DATE: February 26, 2019  
TO: Kari Parsons, PCD-Project Manager  
FROM: Core Engineering Group, Richard Schindler  
SUBJECT: SF-19-003 – Lorson Ranch East Filing No. 3  
Response to Comments Review 1

LORSON RANCH EAST FILING NO. 3

FINAL PLAT  
LORSON RANCH EAST  
FILING NO. 3  
JOB NO. 43-127  
DATE PREPARED: 01/08/2019  
DATE REVISED:  
SF-19-003  
PCL FILE NUMBER \_\_\_\_\_

SITE VISIBILITY AND PUBLIC IMPROVEMENT EASEMENT (TRP.)
DETAIL A
NOT TO SCALE

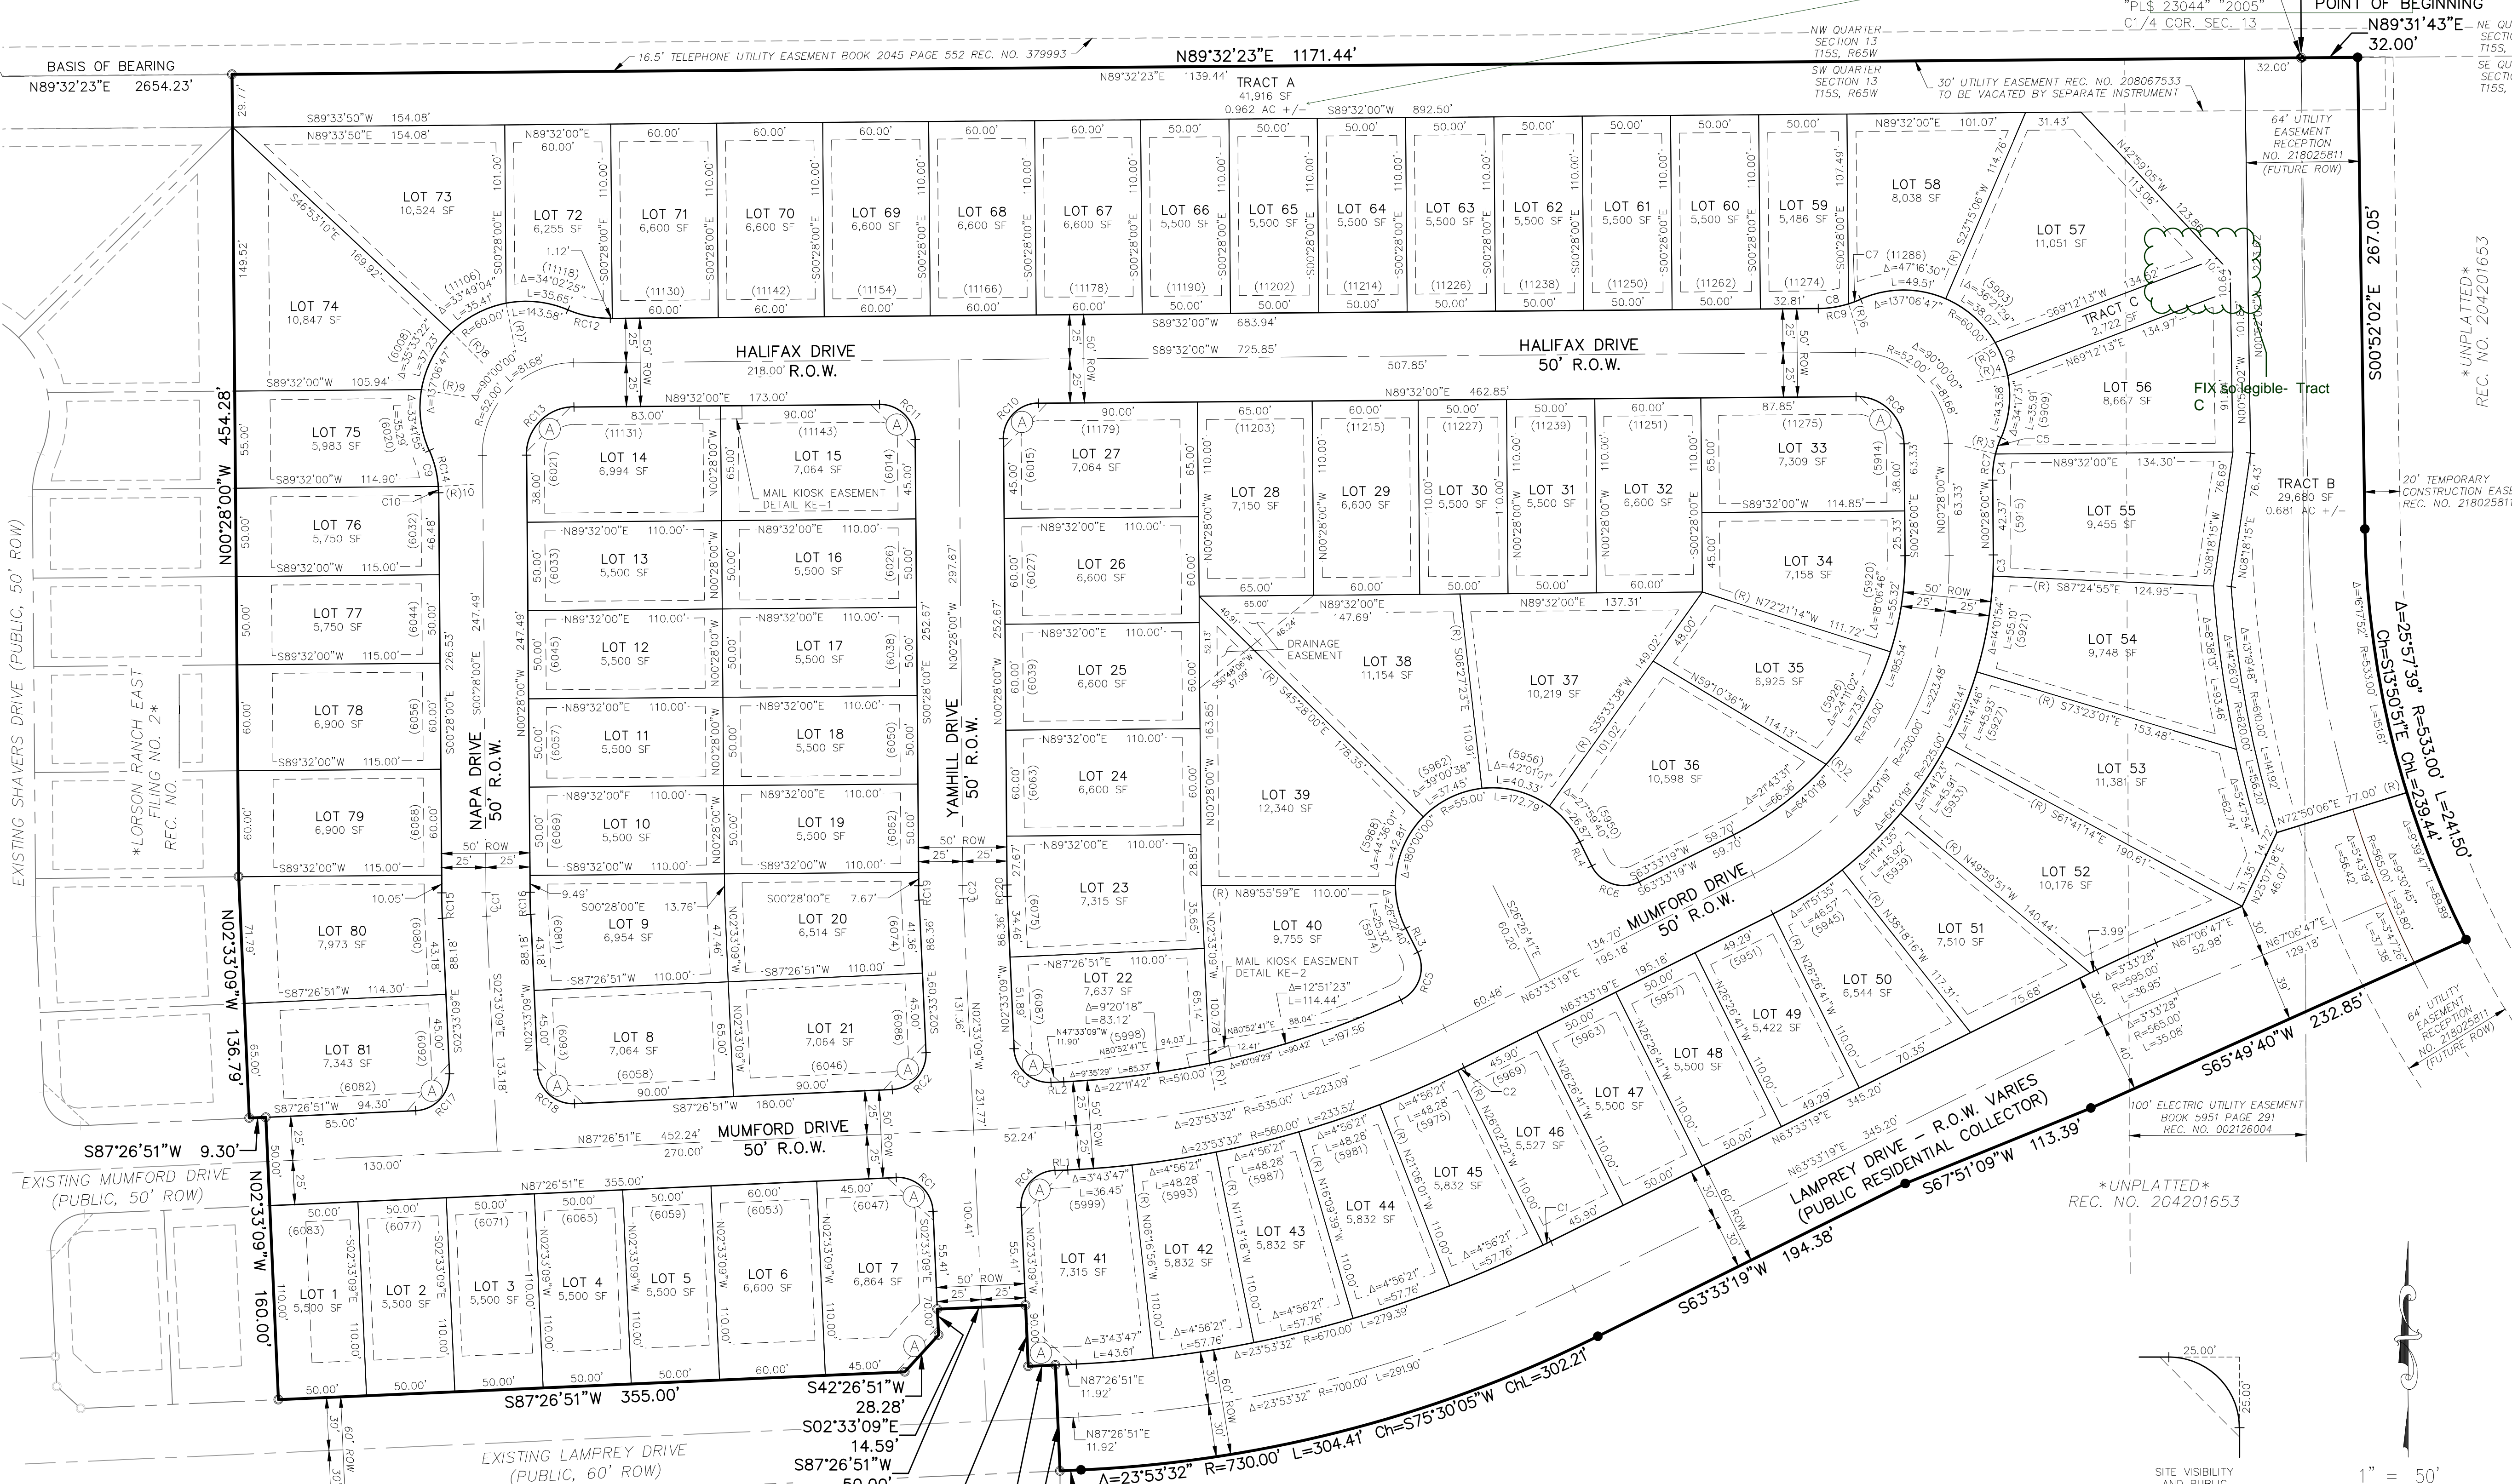
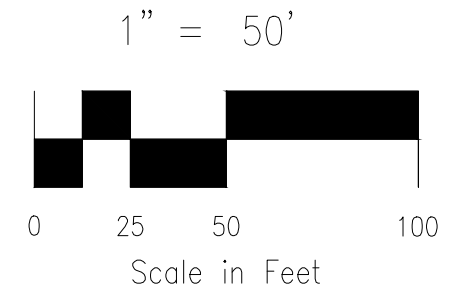
Please add a plat note similar to  
Lorson East Filing No. 1, that  
clarifies this R-O-W area will be  
dedicated to El Paso County at  
no cost when requested.

NOTE 2!  
ADDED TO  
SHEET 2
